Our ref: CE/2011/104929/01-L02
Your ref: 3/2011/0580
Date: 31 August 2011

**PROPOSED CONSTRUCTION OF A MICRO HYDRO STATION INCLUDING A
BUILDING TO HOUSE TURBINE TRANSFORMER AND CONTROL EQUIPMENT
ALSO AN ASSOCIATED FISH LADDER
LAND AT HOLE HOUSE FARM, BRIDGE END, BILLINGTON**

Whalley Community Hydro Fish Pass Issue 2	
Sheet	3/7(2)
Drawn by	
Checked by

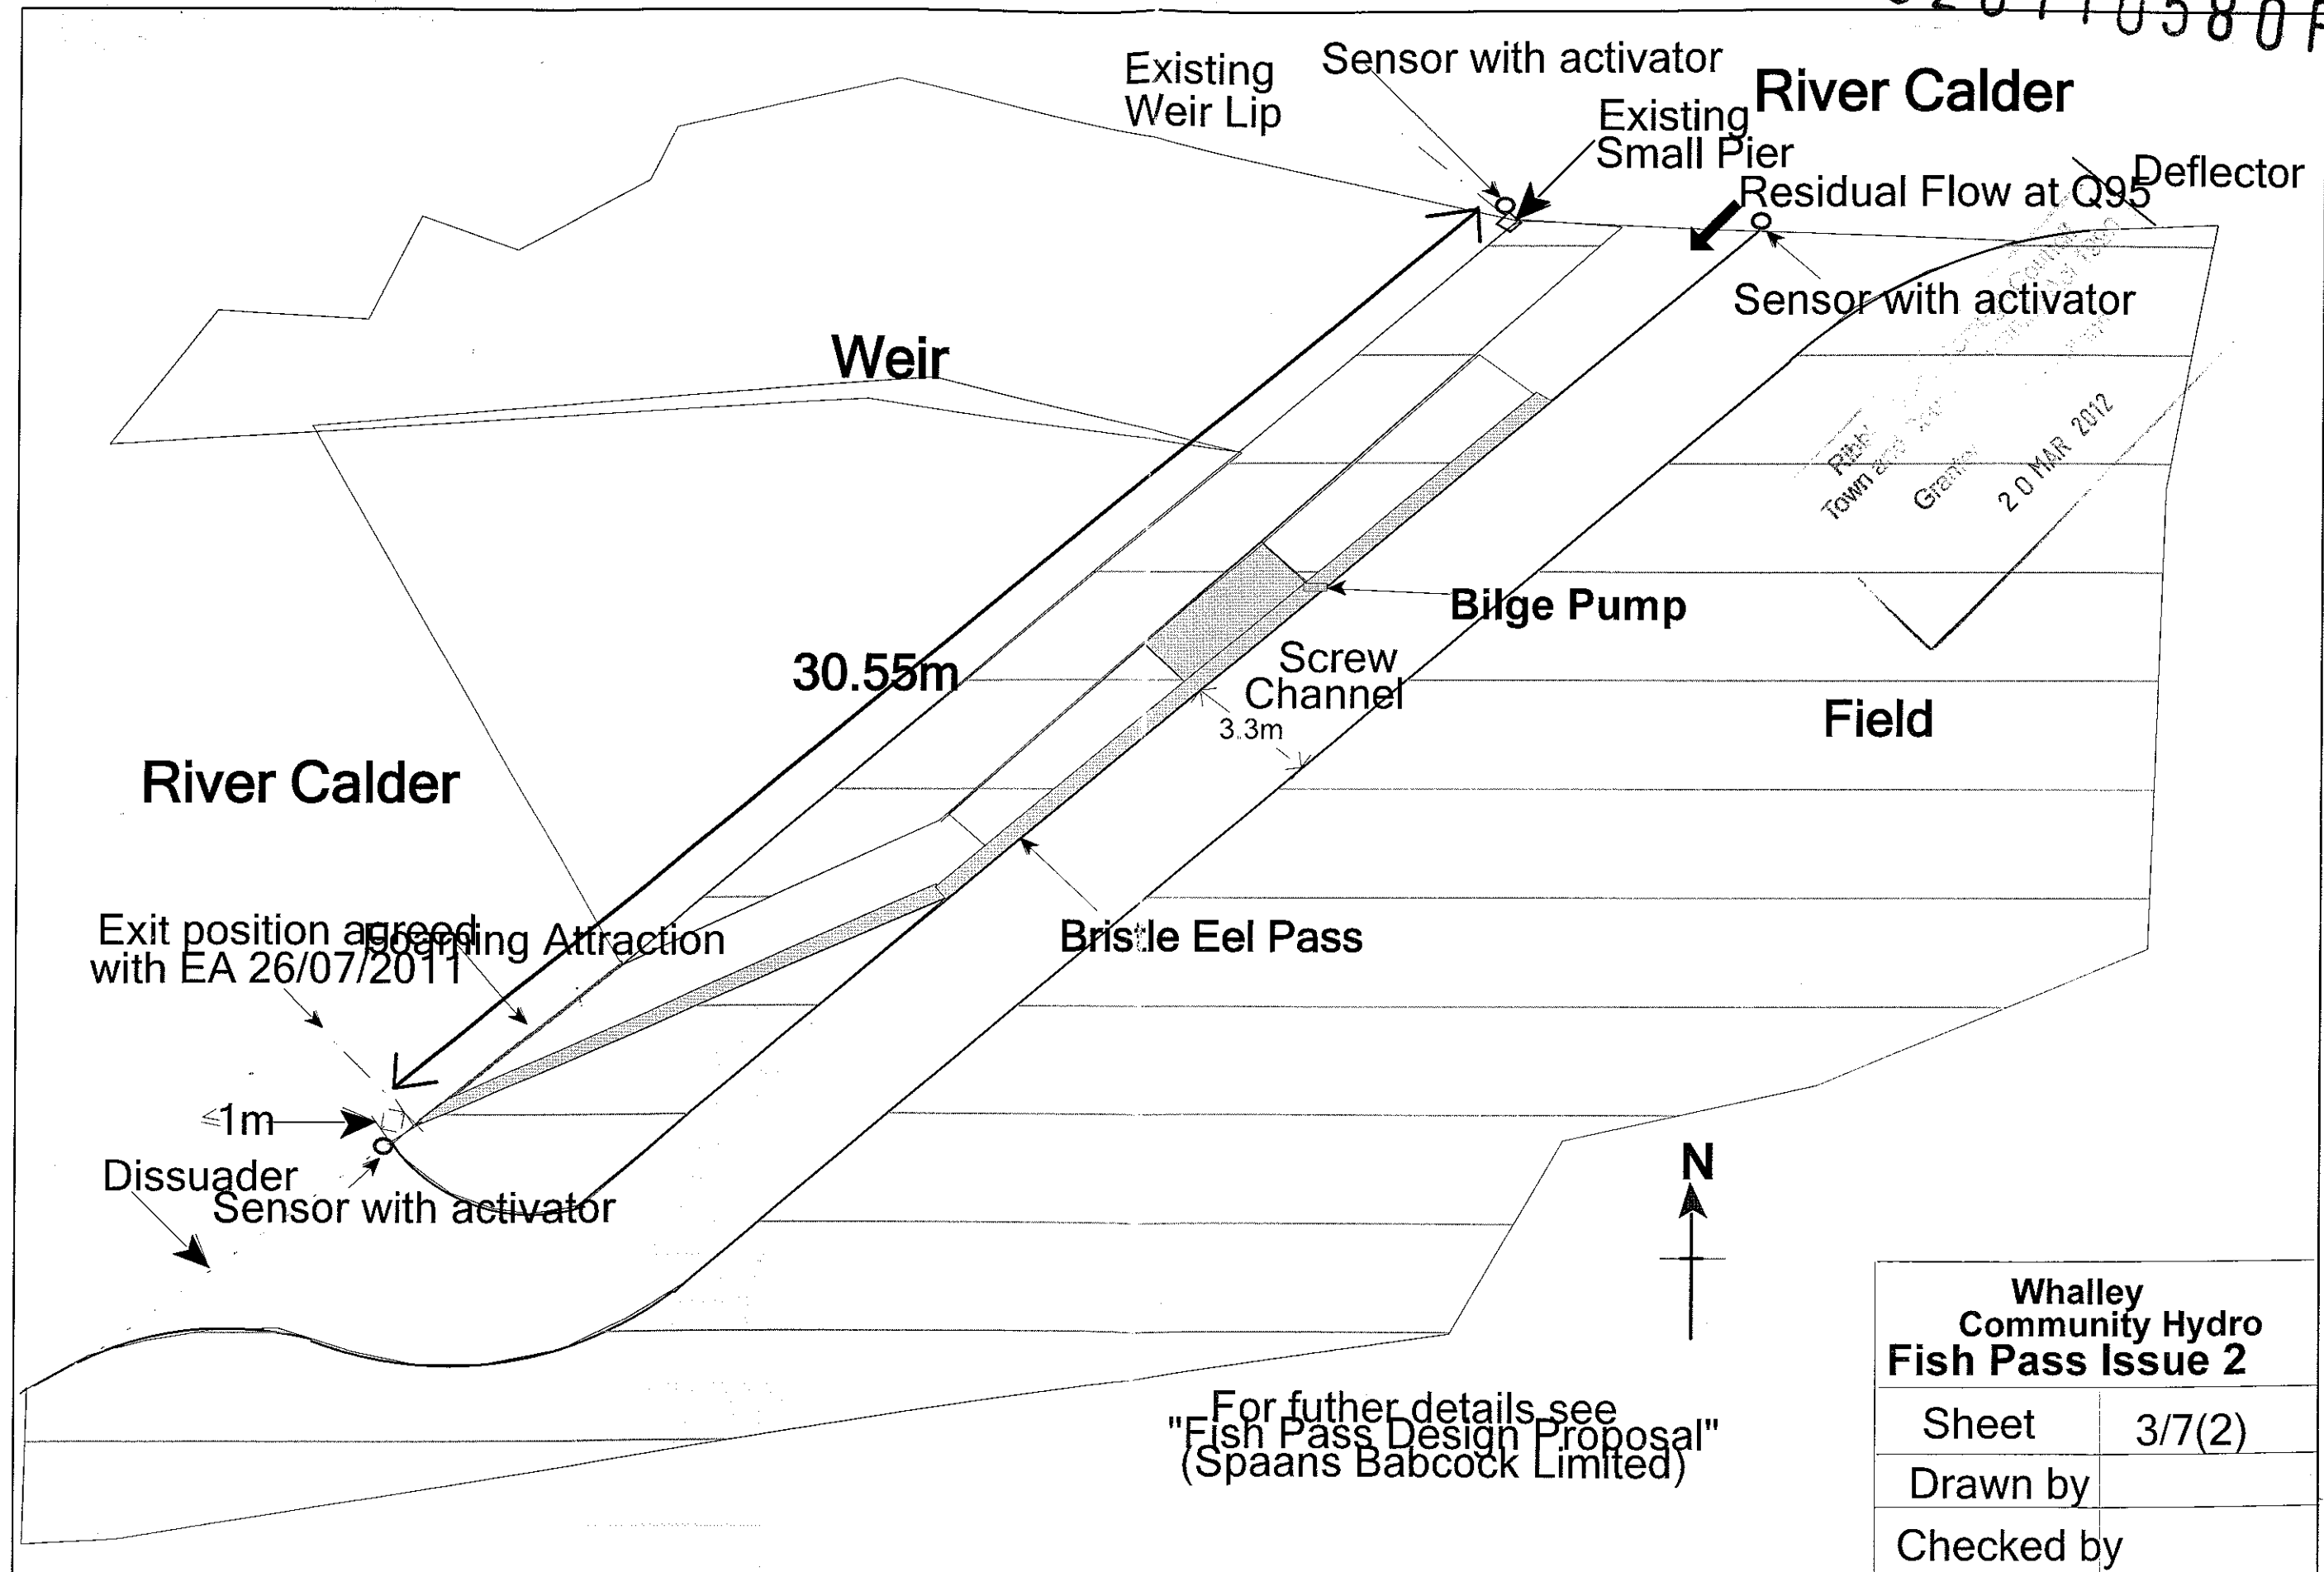
The fish pass as proposed in the application is not appropriate for the scheme and will need to be amended. For the location of the scheme and the fish species present, the gradient of the fish pass should be set at 8% and the design should include two resting pools. The kink in the fish pass also needs to be corrected and the exact position of the fish pass in relation to the outfall of the turbine channel needs to be confirmed.
